6<sup>th</sup> May, 2020

**Re: MOD 2- The Crescent Overpass and Active Transport Links**

Figure 4-2 The Crescent/Johnston Street/Chapman Road layout in EIS and proposed modification model

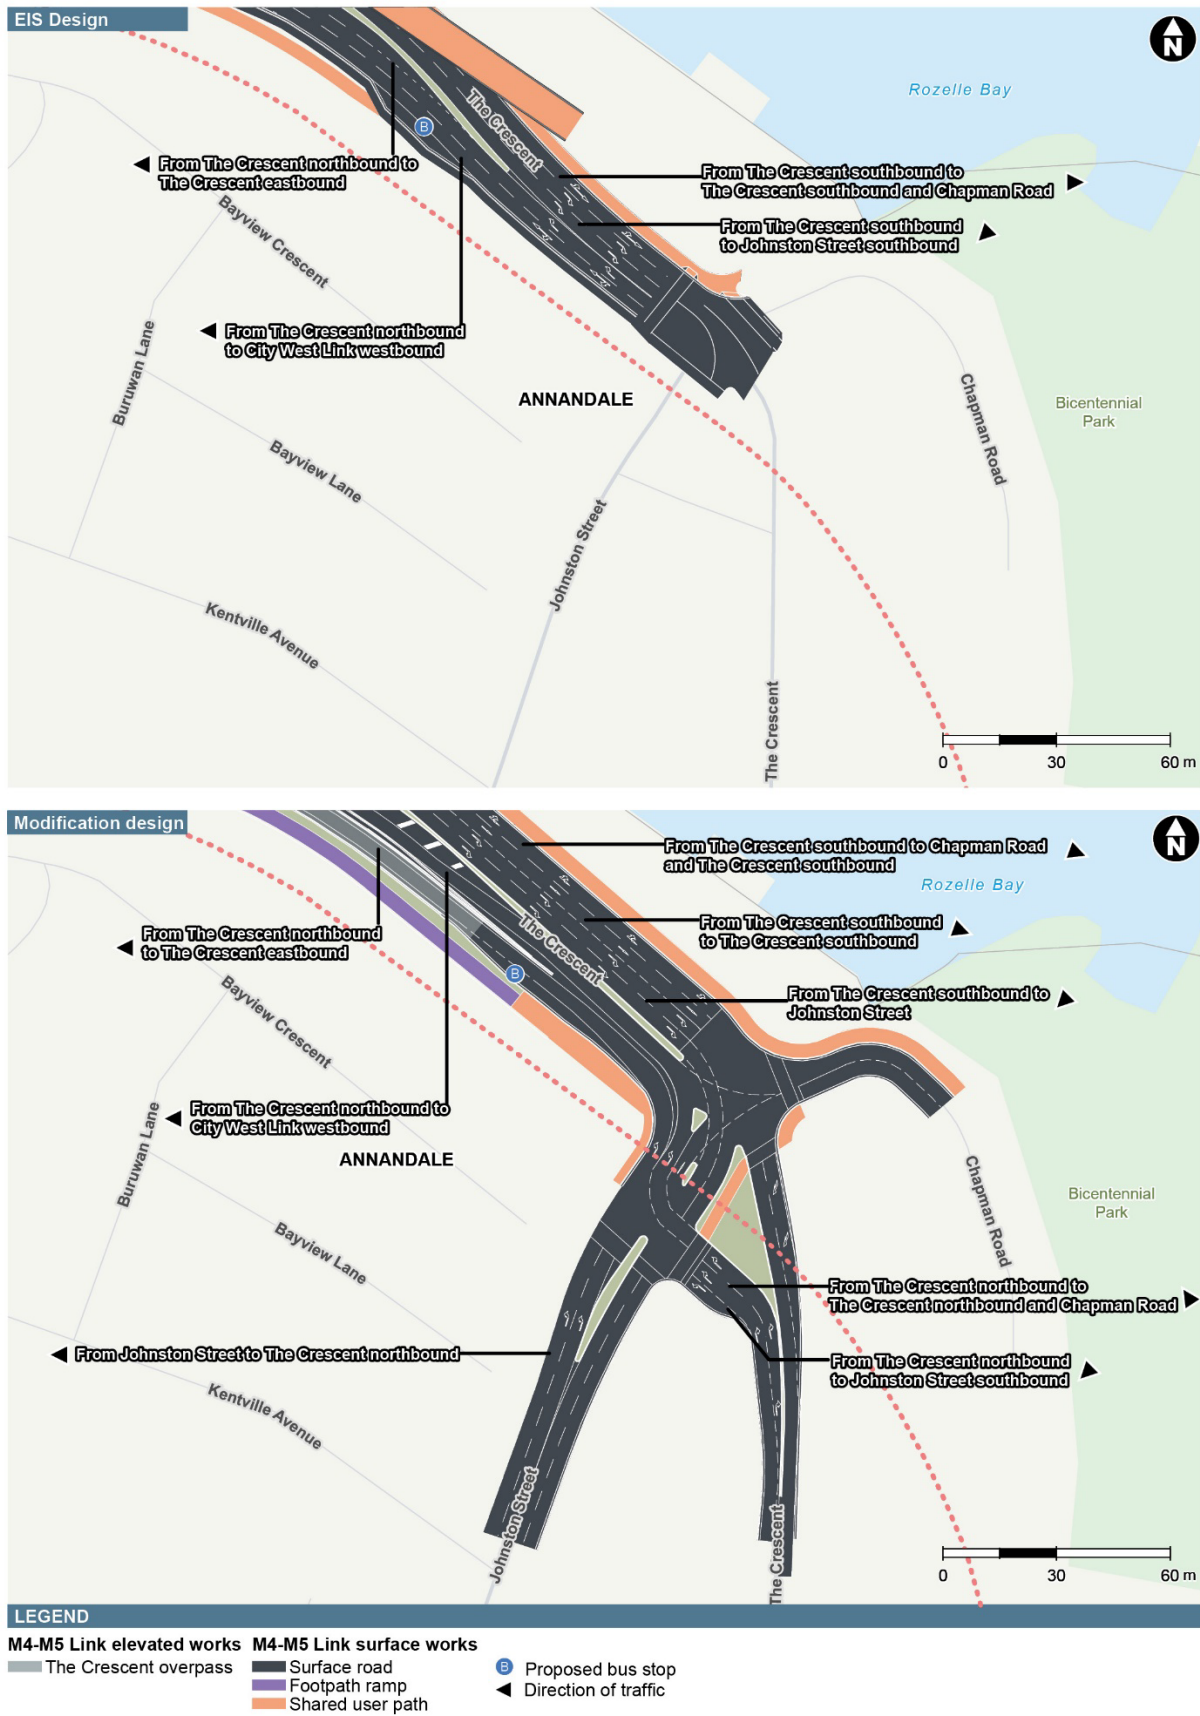
"The length of the pedestrian crossing dictates how long phase B should be to provide safe clearance time for pedestrians i.e. 20 seconds minimum green time. Phase B is 10 seconds longer than the maximum green time in the EIS models due to the wider carriageway and therefore slightly longer pedestrian crossing time."

This does not give a specific phasing duration, but we want to ensure this is sufficient for elders, children and riders to cross safely. This crossing should not have long wait times that encourage people to cross early in frustration, when it takes too long for the lights to change.

**Figure 11 | Broader pedestrian and cycling connectivity** (Source: Design Amendment Report)

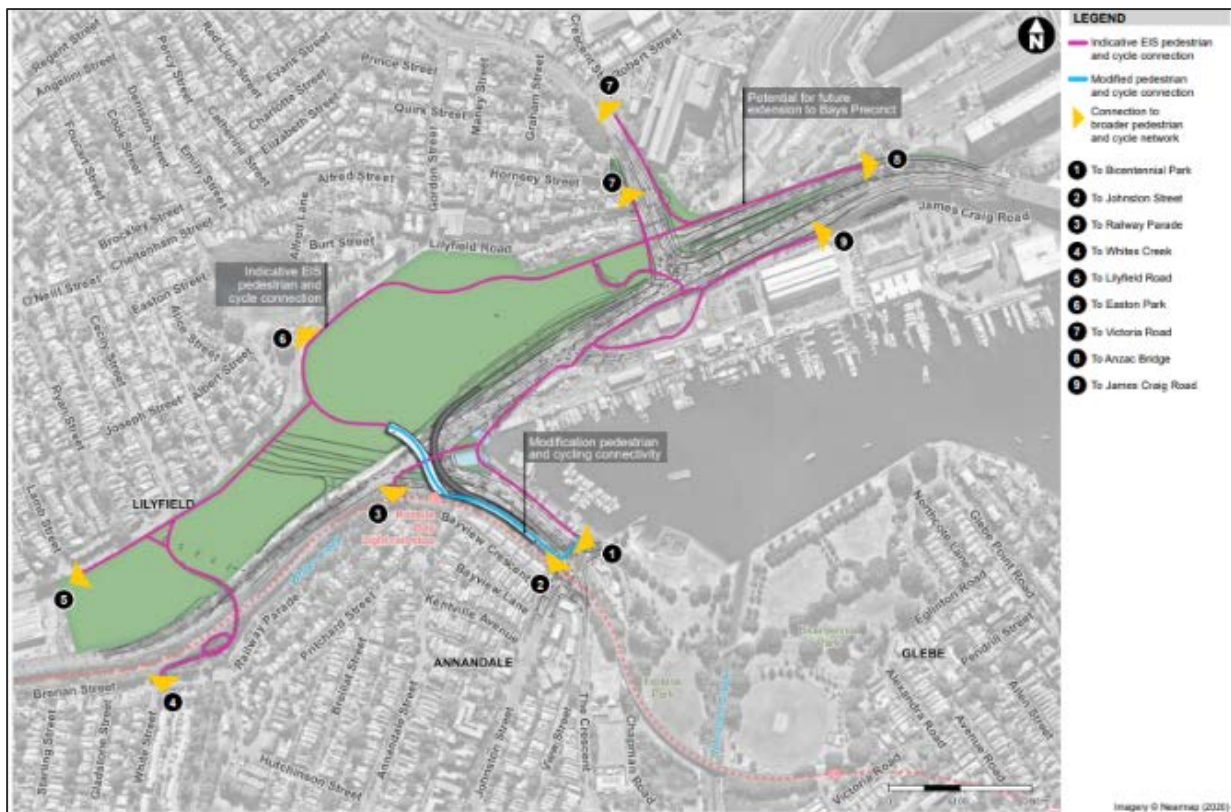
(p 49<sup>5</sup>) Removal of the u-shaped bridge does is not a significant as it was lengthy and indirect. However, we understand and share concerns about the project making it more difficult to connect to the Bays Precinct (White Bay to the light rail, Rozelle Bay, Glebe and Annandale) where it is intended that there will be high density residential development built.

We have marked with a red arrow the priority connection that needs to be built to improve direct connections essential to meet the needs of anticipated residential development.

Bicycle NSW would prefer a tunnel not an overpass to connect across the project between numbers 4 and 5 marked on the above map. This avoids the need for a 14m climb and drop, could connect in better at each side and would have less visual impact in the area for residents

Figure 1-1 The revised design

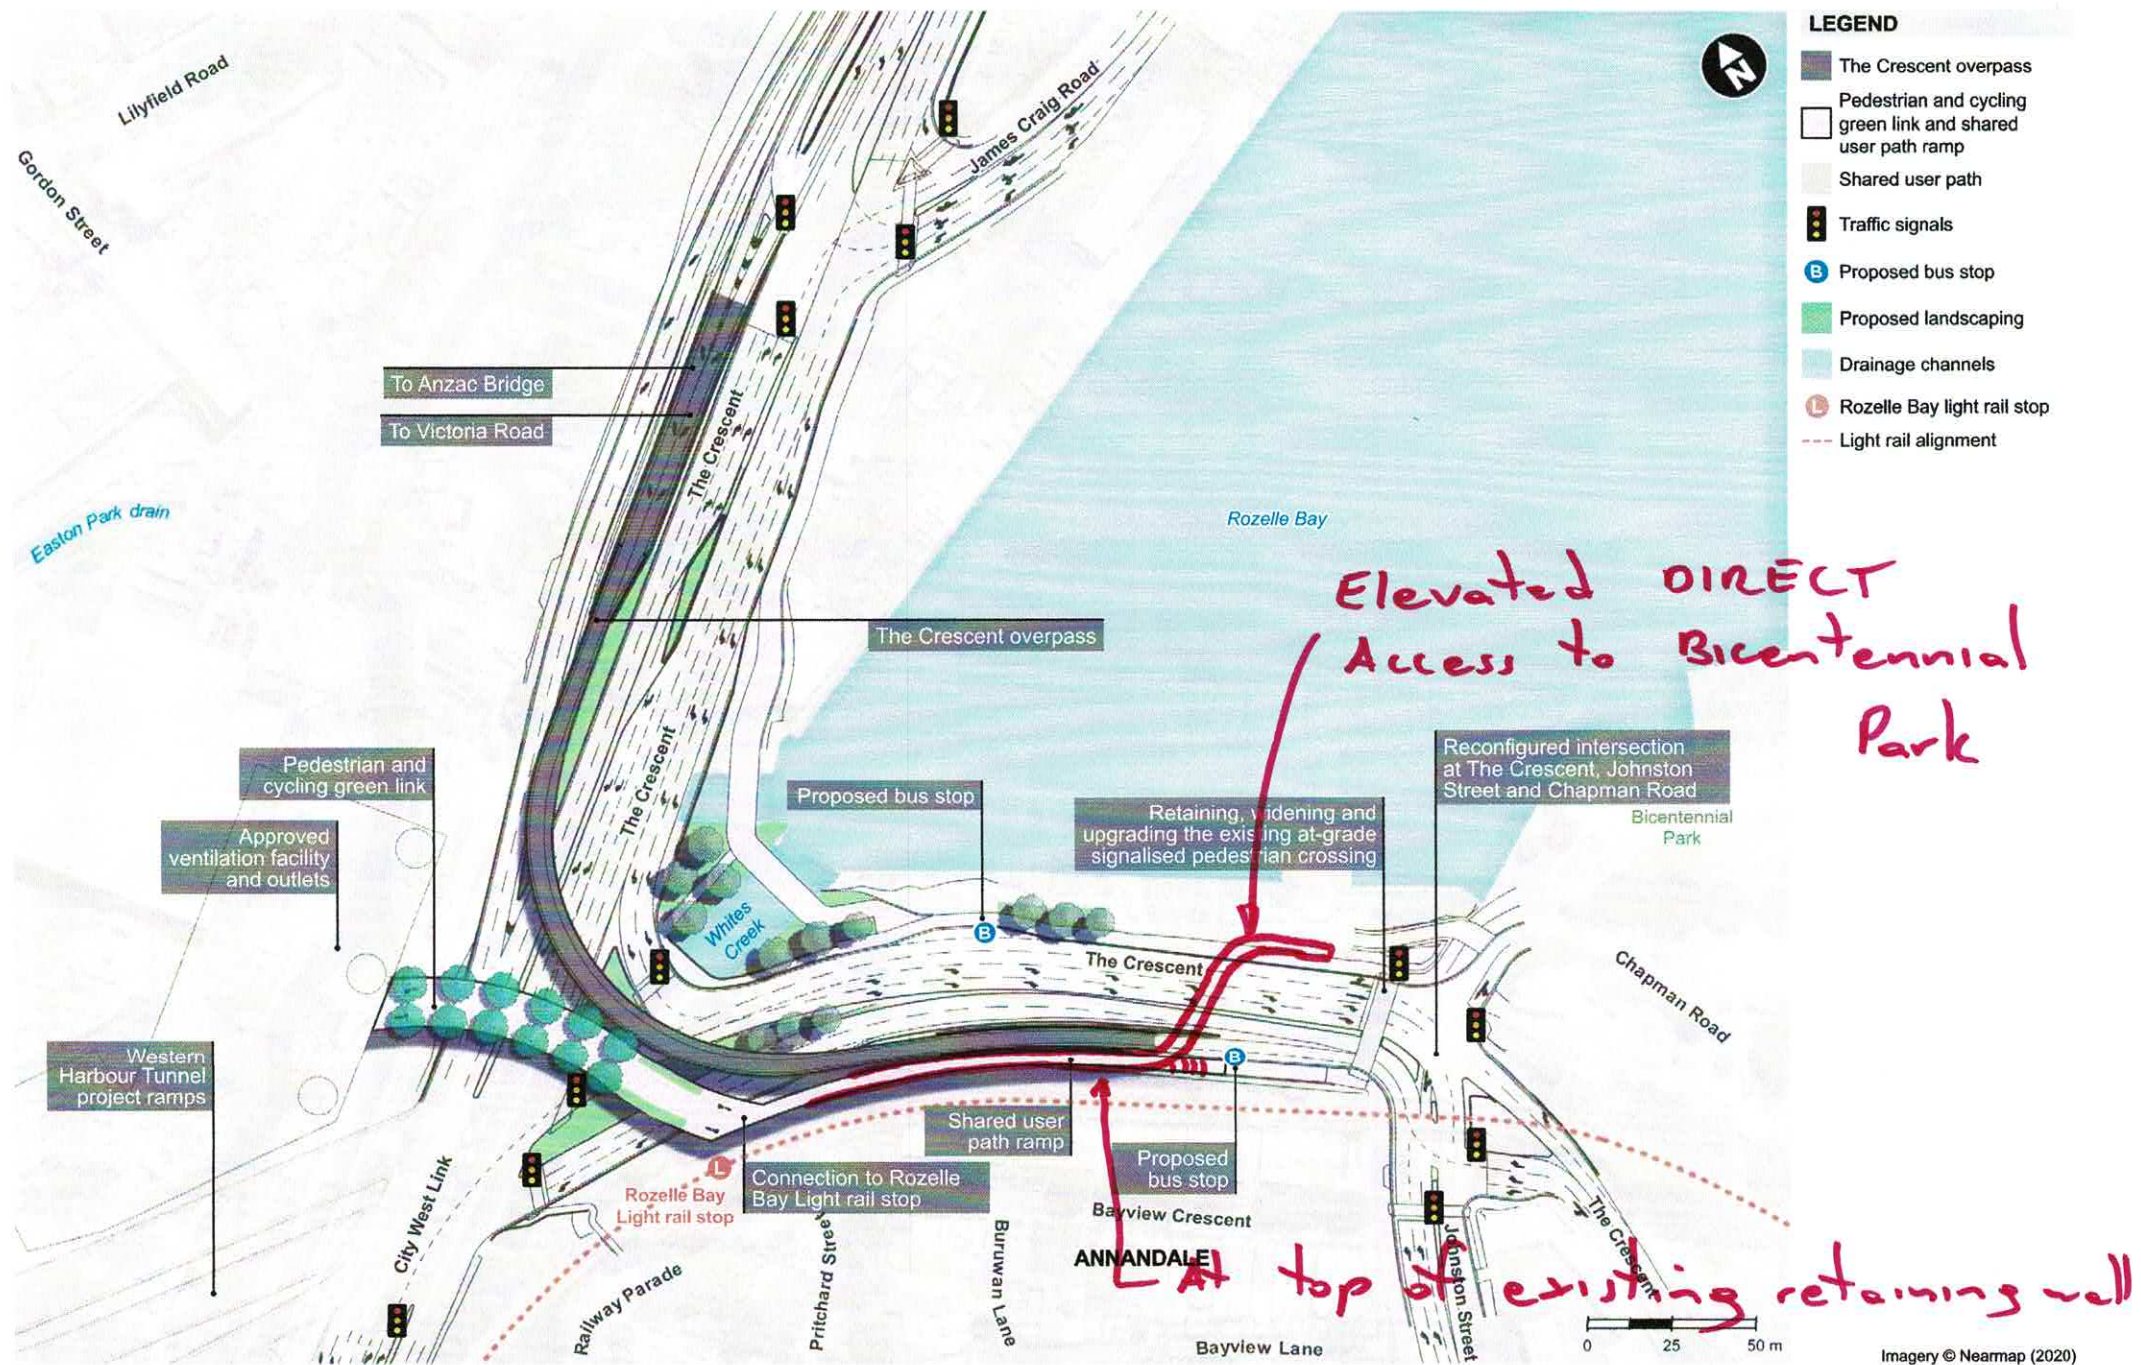
We have been assured that the crossing at Johnston Street will be widened to 6m & include bike lanterns and that the crossing underneath the overpass will have bike lanterns and be made safer for riders, and that the timing of both would be improved and enable safe crossing. This will be a great improvement, and is appreciated.

The footpath area at 300 Johnston St near the rail bridge is to be widened to take groups such as school children going to Jubilee Park. Cyclists from Chapman Rd or The Crescent path will need

some provision for continuing on Johnston St, and cyclists coming north Johnston St will need a bike lane leading to the corner, which was there until recently taken over by the utility works near 300 Johnston St. Council and the Proponent need to provide bike lanes either side of Johnston St, at least up to Rose St, where cyclists can get off Johnston onto Annandale St or other routes. If this project can't provide them, then it shouldn't prevent them being provided in future.

A shared path/bicycle path is needed from the east side of the proposed new Johnston St crossing to The Crescent and south to the current refuge crossing on The Crescent, opposite the skate park being constructed.
